5th September 2019

- A. Highways England A303 Amesbury to Berwick Down - Consultation on Proposed Non-Material Changes to the Development Consent Order Application

NMC-01 – Existing A303 lay-by west of Winterbourne Stoke to be de-trunked.

INSET 1
SCALE 1:1000

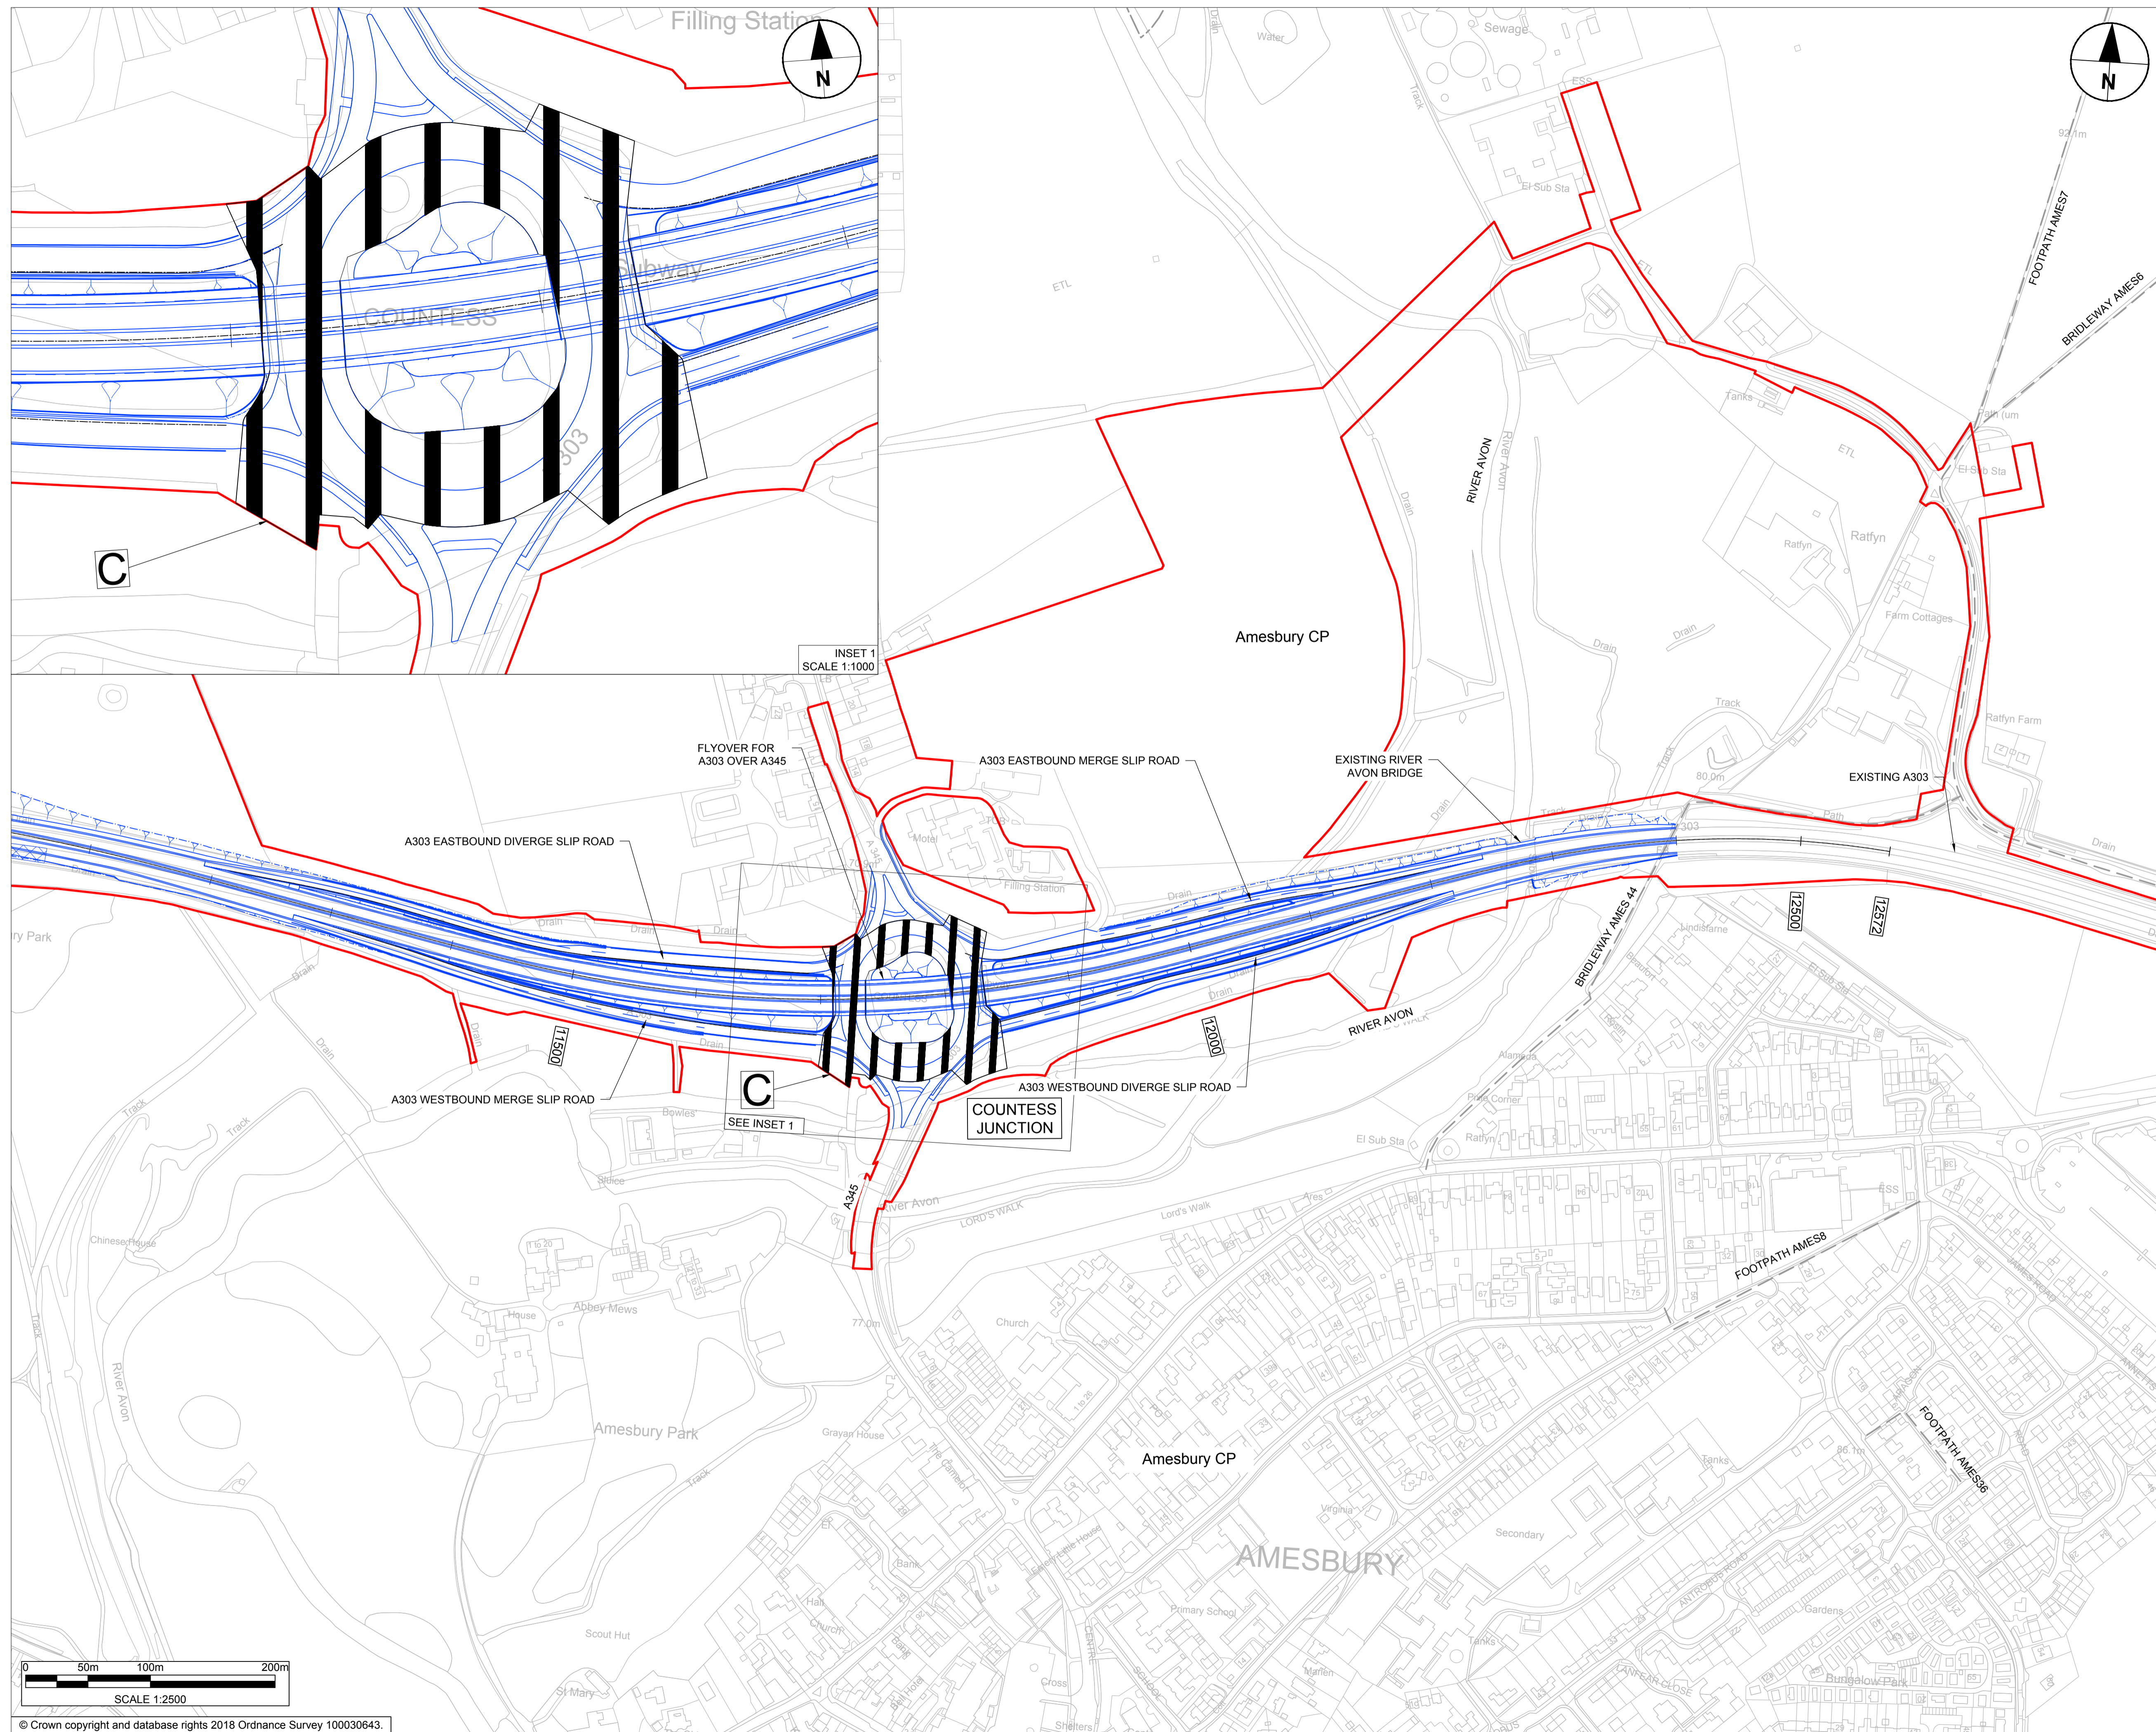
The proposed re-categorisation of the lay-by is welcomed in that it will be “....transformed into a sloping grassed verge that will no longer be accessible to vehicles”. Clarification is however requested on the following points:

- It would aid transparency if the nature of the “transformation” is detailed precisely. For example, is this transformation the complete filling-in of the lay-by or simply the recategorization of the land area. This is important as the reason for this area being brought under scrutiny is in order to prevent it from becoming a focus point for unlawful and antisocial activity. Reassurance is required that the detail behind the “transformation” prevents such activity occurring.

- Clarification is requested as to how this area will “no longer be accessible to vehicles”. Prevention of access can be achieved in a number of ways ranging from the erection of signage to the building of fencing and walls. Clarification is requested as to how vehicles will be prevented from obtaining access to this area.

- It is stated that the lay-by will be handed over to the responsibility of Wiltshire Council. Clarification is requested as to the point in time when this hand over will take place. i.e. Will the transformation be resourced within the Highways England budget for the road scheme or will the responsibility for funding and completion of the works be the responsibility of Wiltshire Council? It is suggested that all these works should be completed by Highways England.

- As stated previously, it is believed that a far more cost-effective method (both short term and long term) of managing this area would simply be to return it to agricultural land and return it to the ownership of the original landowner.

The proposed declassification of the existing A303 from its current road status to an unclassified road does very little to allay the concerns of the undersigned as to future usage of the de-trunked A303. Previous correspondence have listed, at length, the impact of leaving this road freely accessible to all road users. In effect, if the plans are to remain unchanged, this length of road will become the focus of all the antisocial and unlawful activity that currently exists on the roads and byways around Stonehenge that this road scheme is being used to prevent. All this current proposal achieves is to push that activity away from Stonehenge to impact on neighbouring landowners and specifically in the area of this de-trunked section of the A303. It is not disputed that access is required to be maintained along the existing A303 for the purposes of the maintenance of national infrastructure as well as for agricultural access. No other access is required along the de-trunked A303 and therefore this element of road should be gated from the point immediately west of the current access to Scotland Lodge Farm.
